CITY OF ALBUQUERQUE

May 8, 2019

**Re: Tract B1 North Gateway
Erosion and Sediment Control Plan
CPESC's Stamp Date 4-30-19 (B18E024)**

EROSION AND SEDIMENT CONTROL PLAN

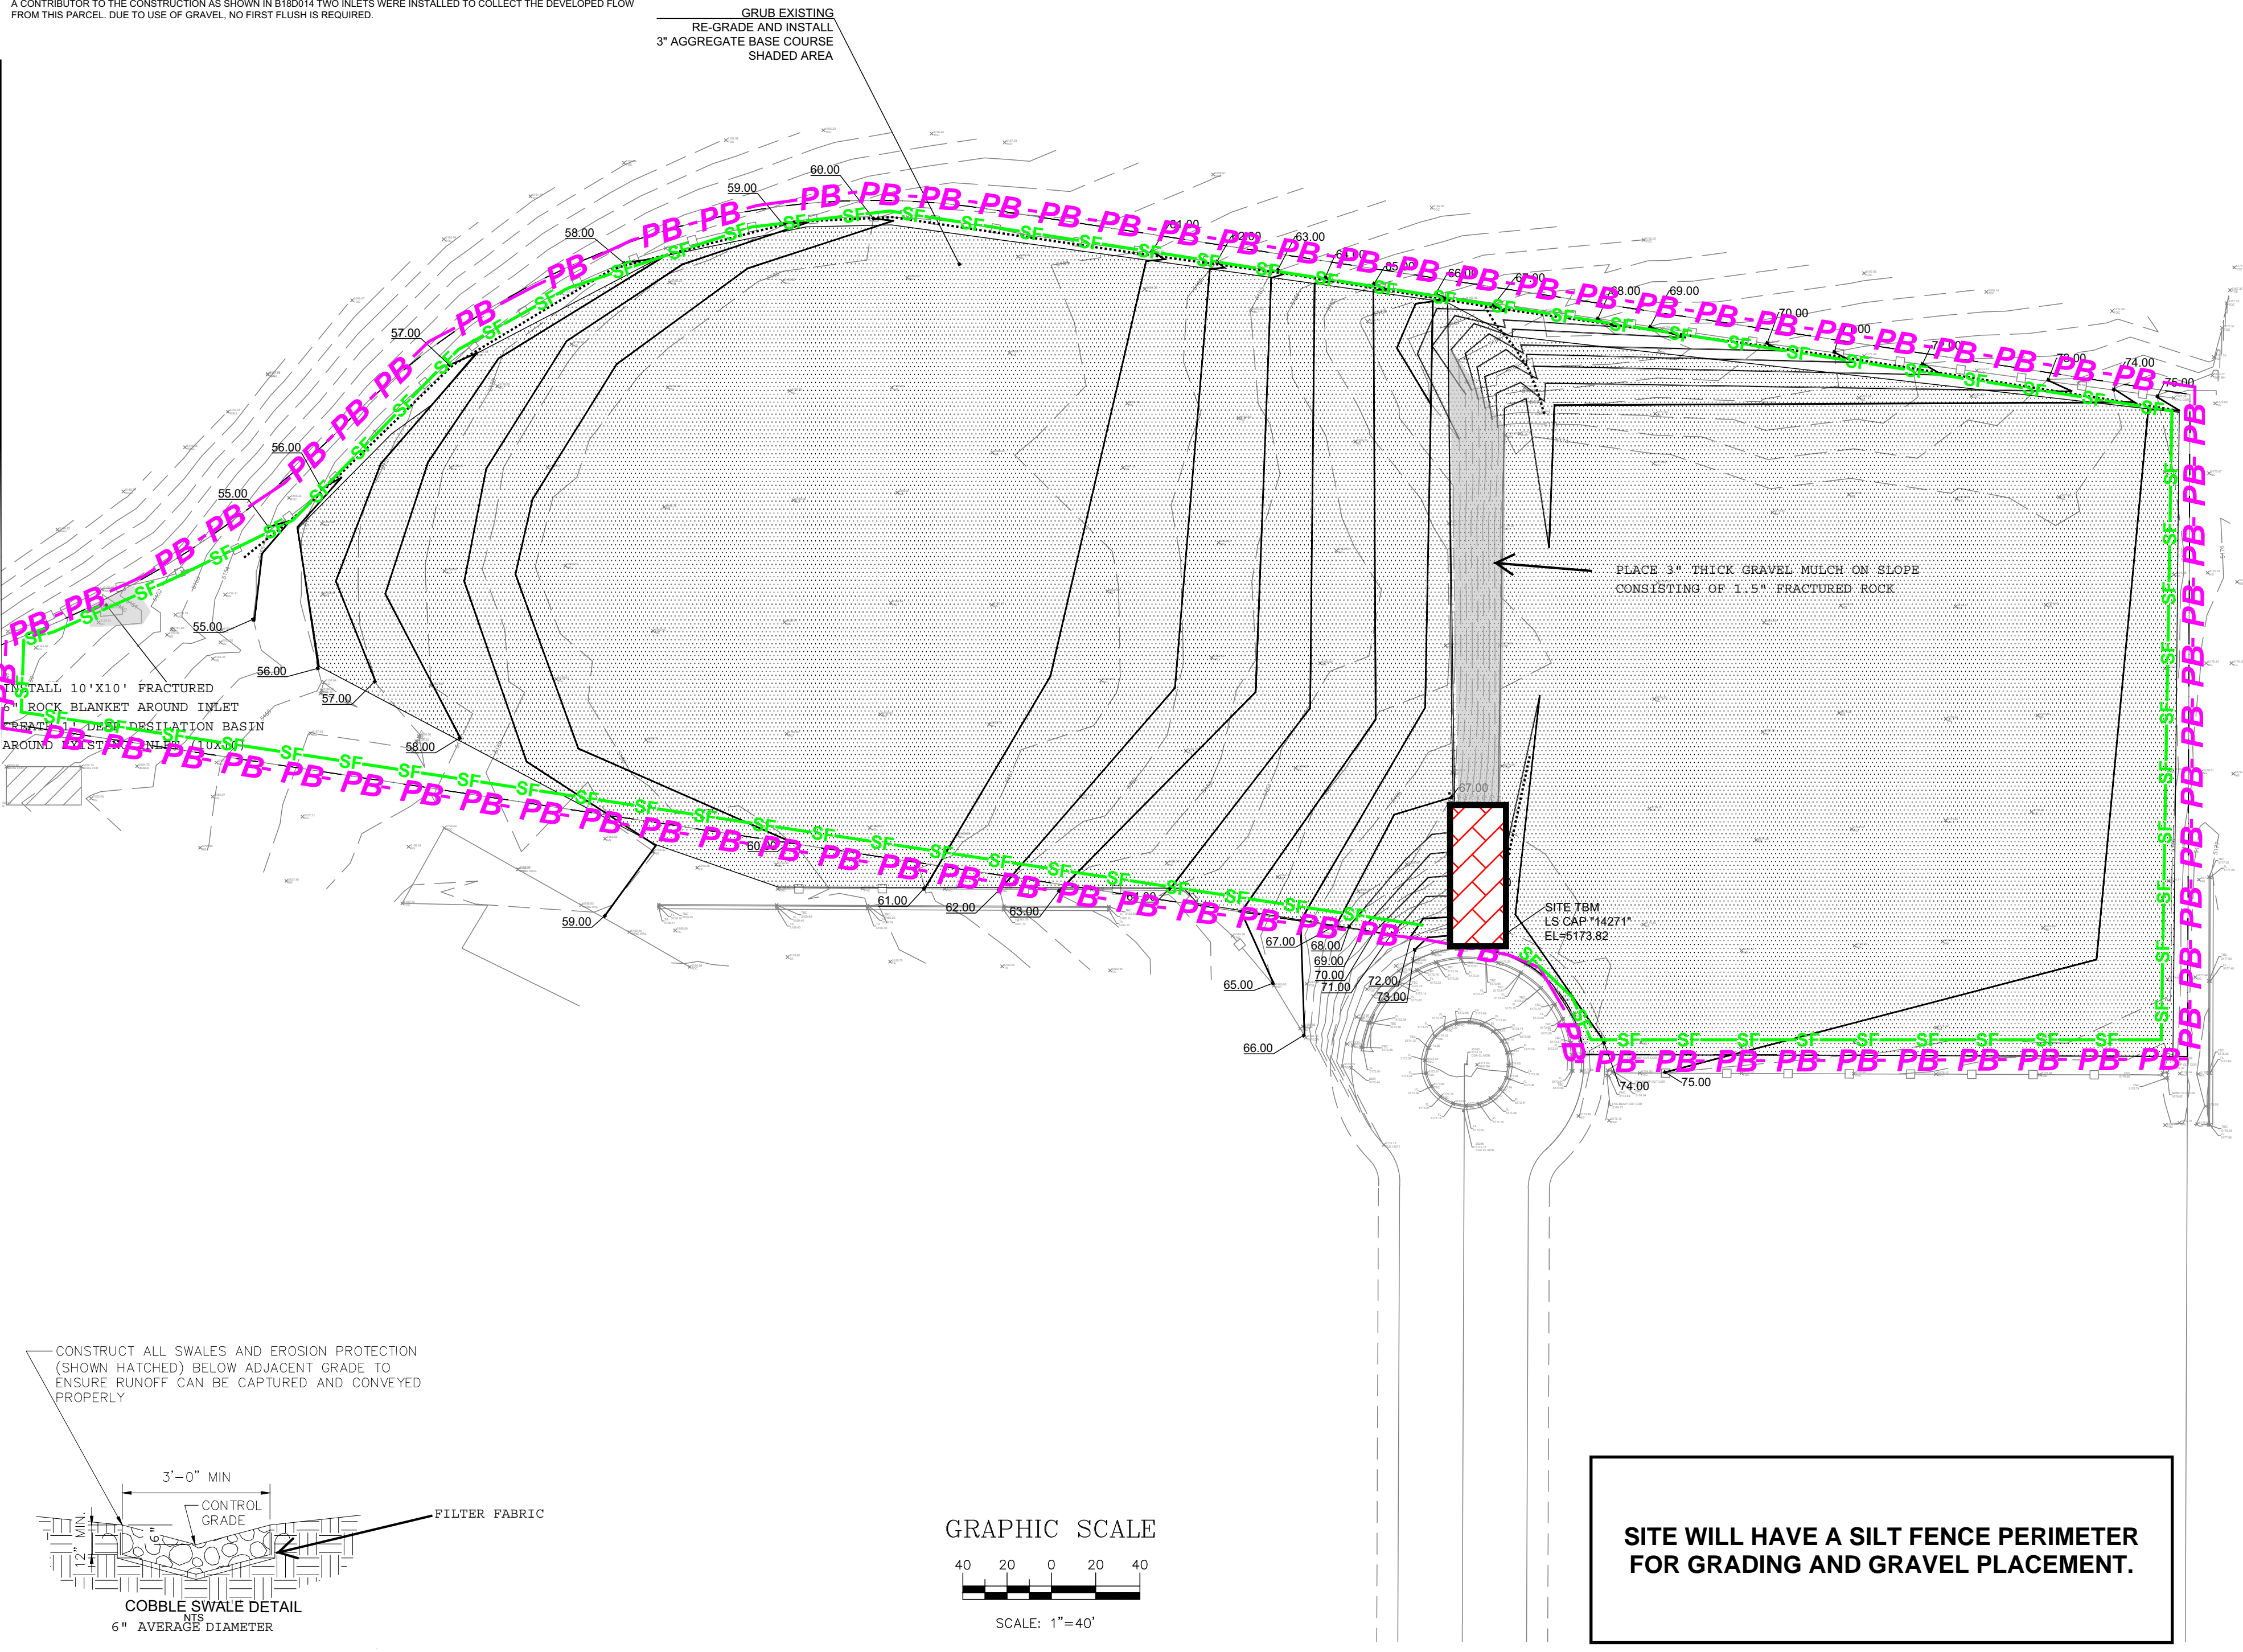
1. Existing inlet(s) will have inlet protection.
